Recommendation Report for Planning Permission for Works or Extension to a Dwelling

REF NO: AL/116/21/HH

LOCATION: Field Place
Nyton Road
Aldingbourne
PO20 3UA

PROPOSAL: Erection of part single, part two storey side extension with first floor rear balcony and 1 x front dormer, and front porch extension following the demolition of side link building and part garage

project: 21/C04
drawing no: 2b
date: June 2021

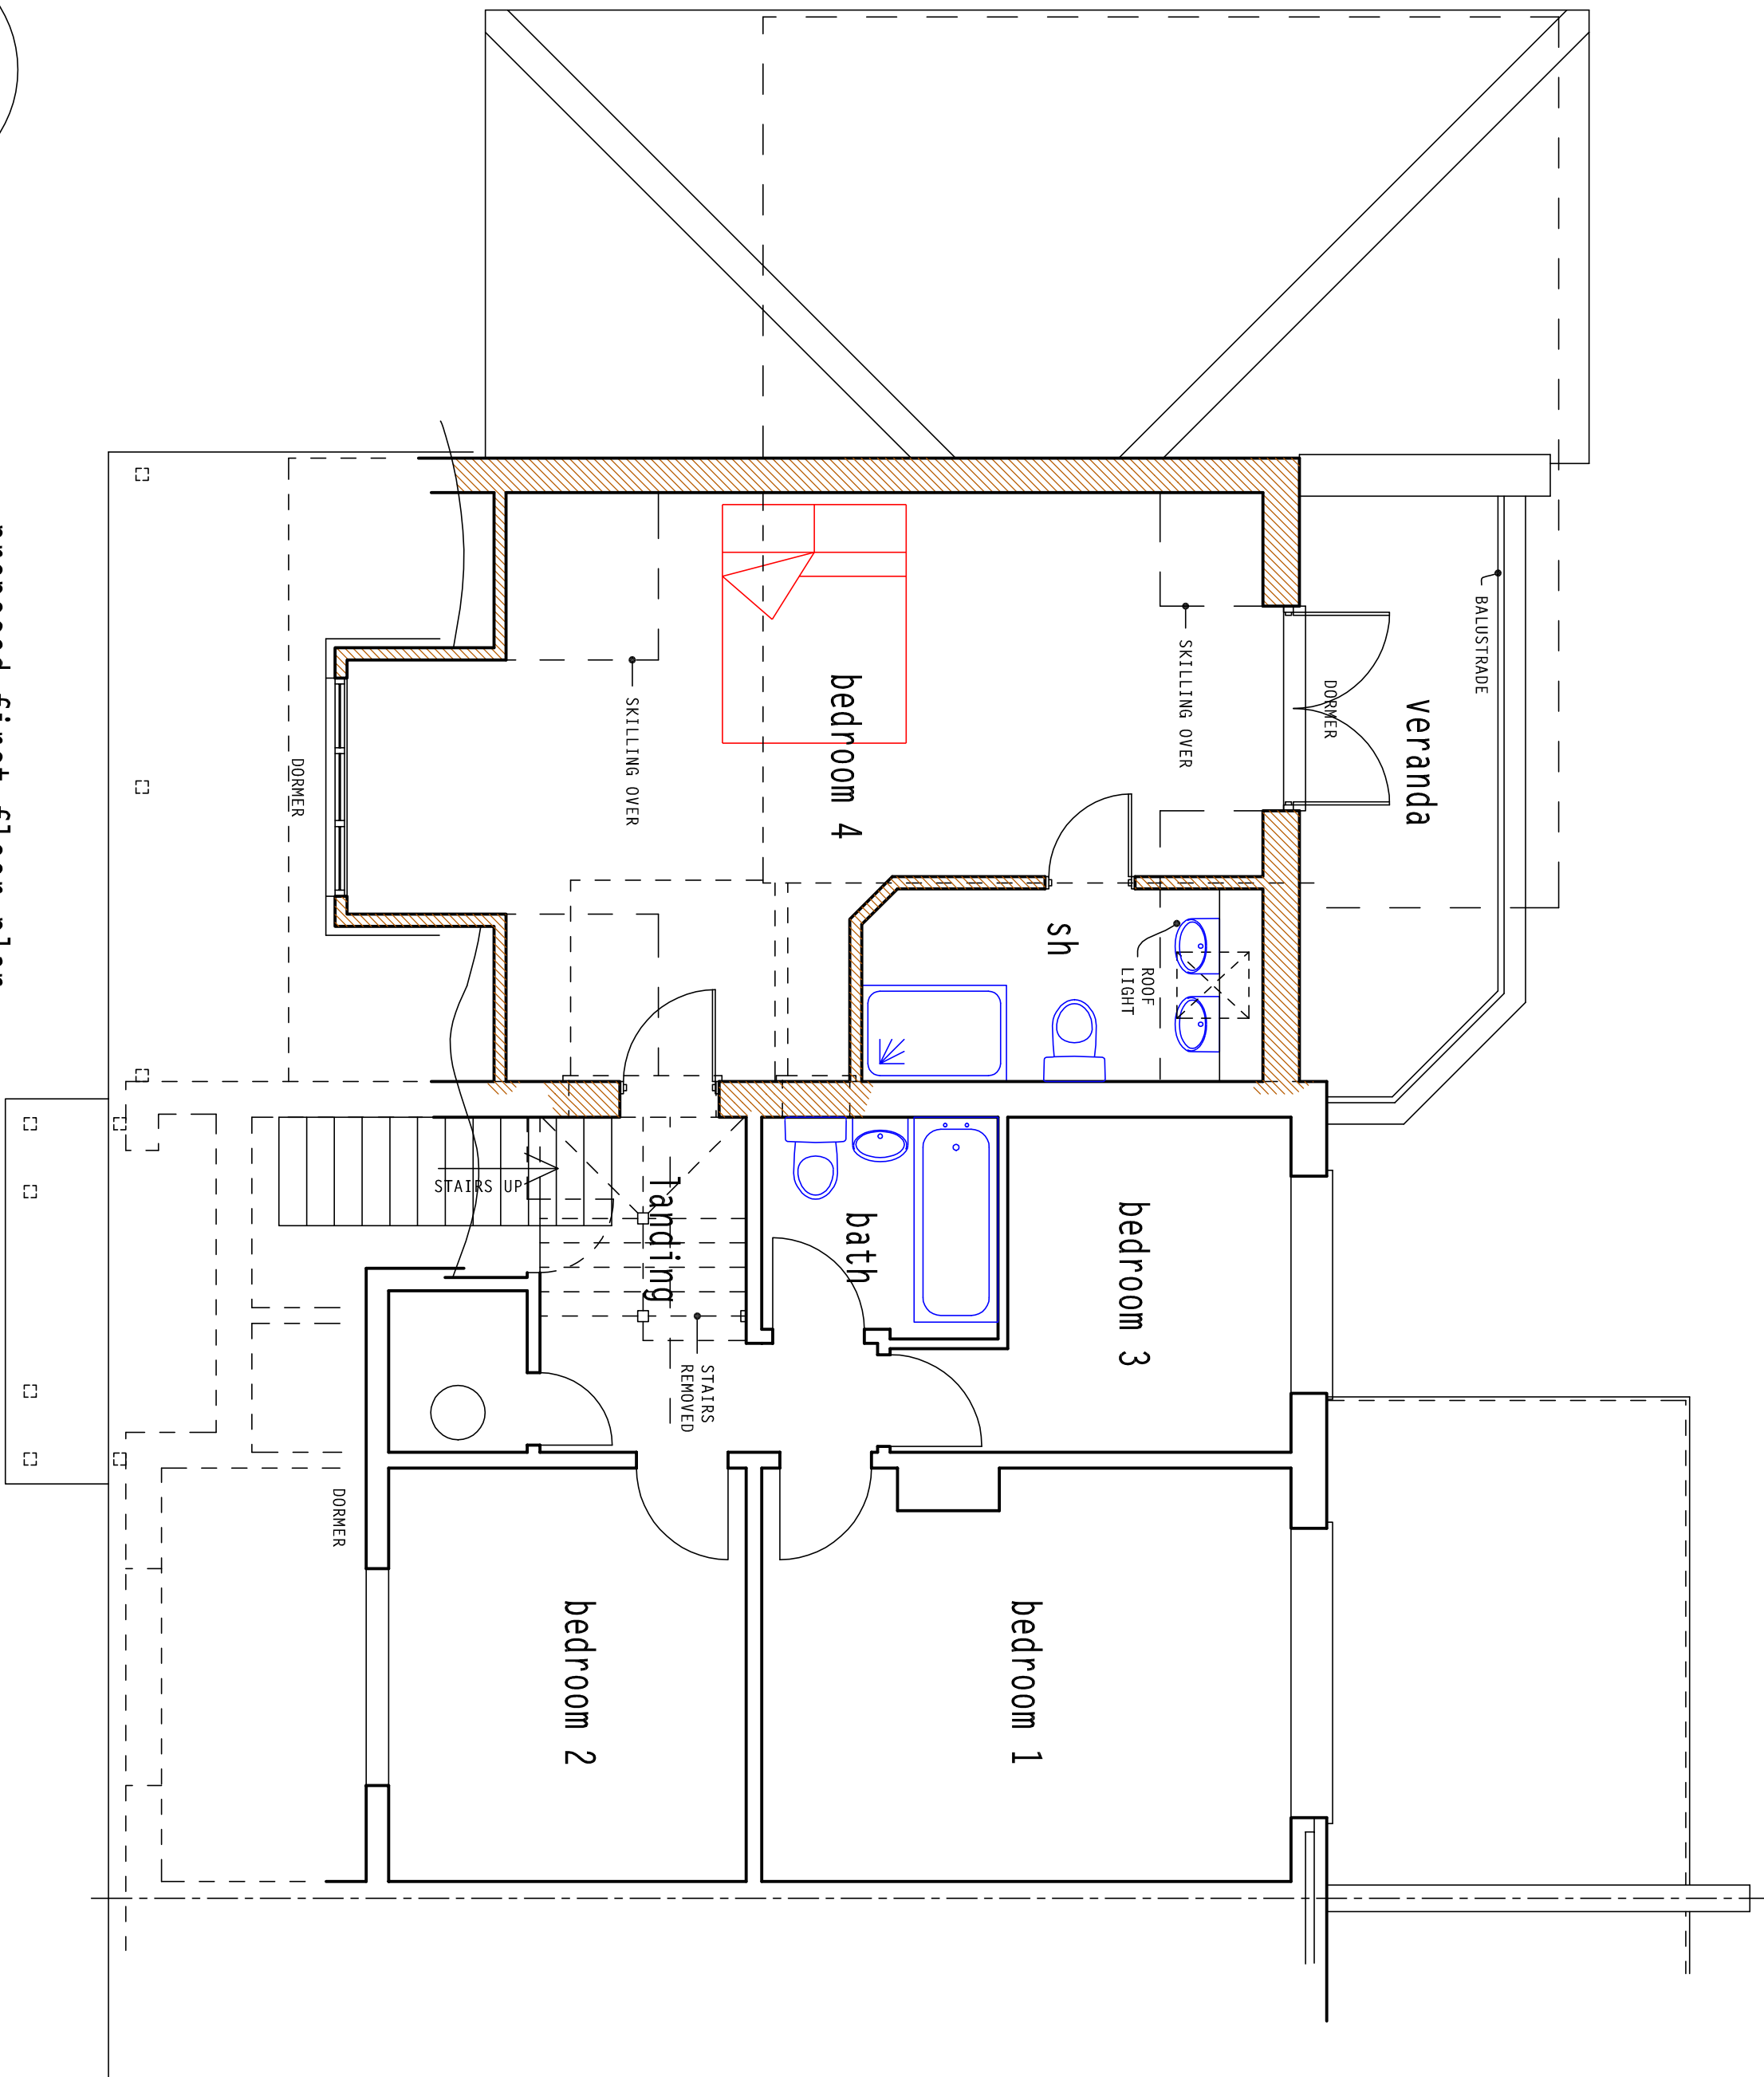
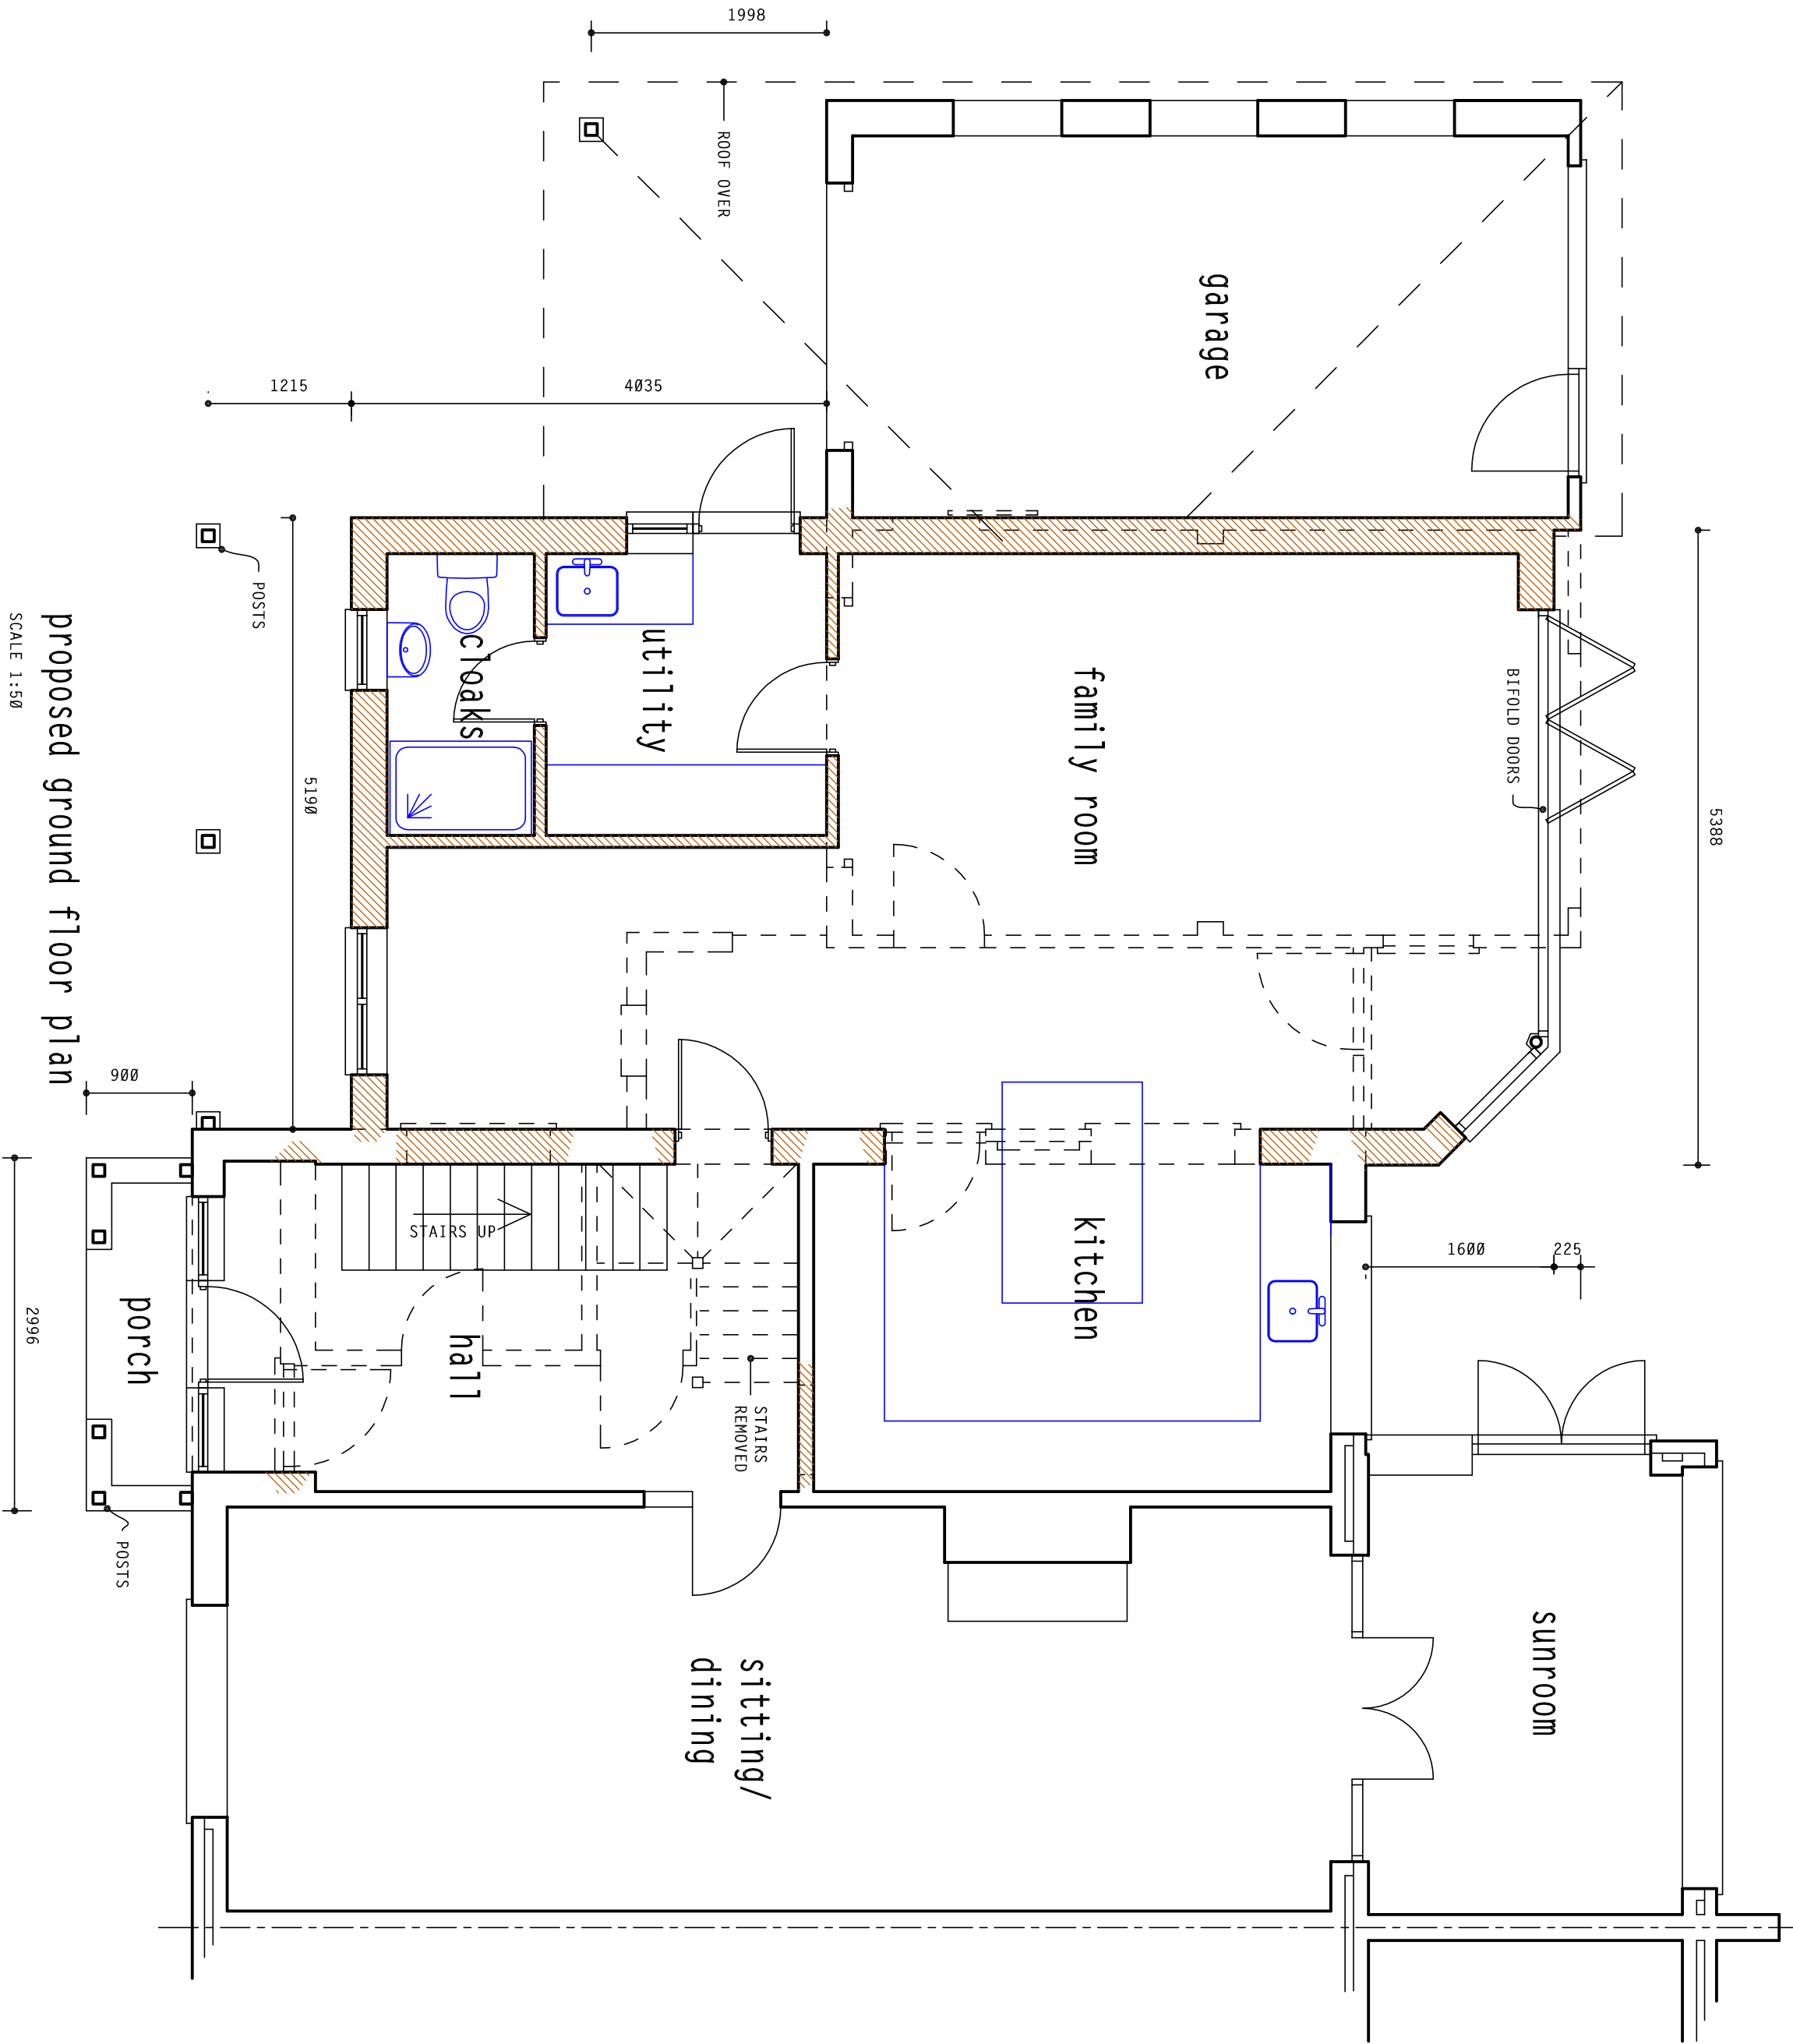
The development adds bulk to the side of the dwelling and as such is not considered to appear a subservient addition in conflict with D DM4 (b). However, it does appear well integrated with the host dwelling, with matching eaves height and materials. It will have a gable end roof and the single storey addition will have a lean to roof.

There will be a covered porch which is located forward of the two storey extension, meeting with the principal elevation. It will extend in line with the eaves and with it open in appearance it is considered acceptable and does not appear unduly dominant.

The two storey side extension extends further forward than the existing garage by approximately 2.25m although still remains 1.35m behind the principal elevation. The single storey garage is located further back retaining around 5.5m to the principal elevation.

There will be a front facing dormer which has a width of 1.2m, depth of 2.5m and a height of 1.5m. This is modest in size with a flat roof, matching the design of an existing dormer to the host dwelling.

The Arun Design Guide states ' roof extensions should favour small scale dormer windows with pitched roofs over large, flat box-shaped designs'. The proposed does have a flat roof dormer which conflicts with this statement however the host dwelling has an existing flat roof dormer and it appears integrated with the existing design. There is a small pitched roof dormer to the rear. 'Side extensions should in most cases be set back from the front of the house and set down from the existing roof ridge height by a minimum of 0.5 metres', which the proposal complies with.

The two storey extension will have a width of 5.15m and run along the full side elevation and slightly beyond the rear, forming a balcony at first floor. The side extension will then reduce to single storey with an additional 3.5m width, although the depth will reduce.

The two storey addition will extend 1.6m beyond the rear elevation which will form a balcony at first floor. This will be accessed via a proposed pitched roof dormer. This is modest in size with a depth of 1.6m and a width of 4.85m.

This will have views over the garden of the property to the north west at Tabbuenella. This is not considered to provide views into direct windows due to the siting of the properties, however would still provide additional views over the garden which are not currently achievable. As such, it will be conditioned that screening should be provided to the north west boundary to limit adverse overlooking.

- 3 Balcony screening shall be installed to the north west elevation of the rear balcony and at all times be obscured glazed and to a height of 1.7m. This shall be installed prior to the first use of the balcony and be retained thereafter in perpetuity.
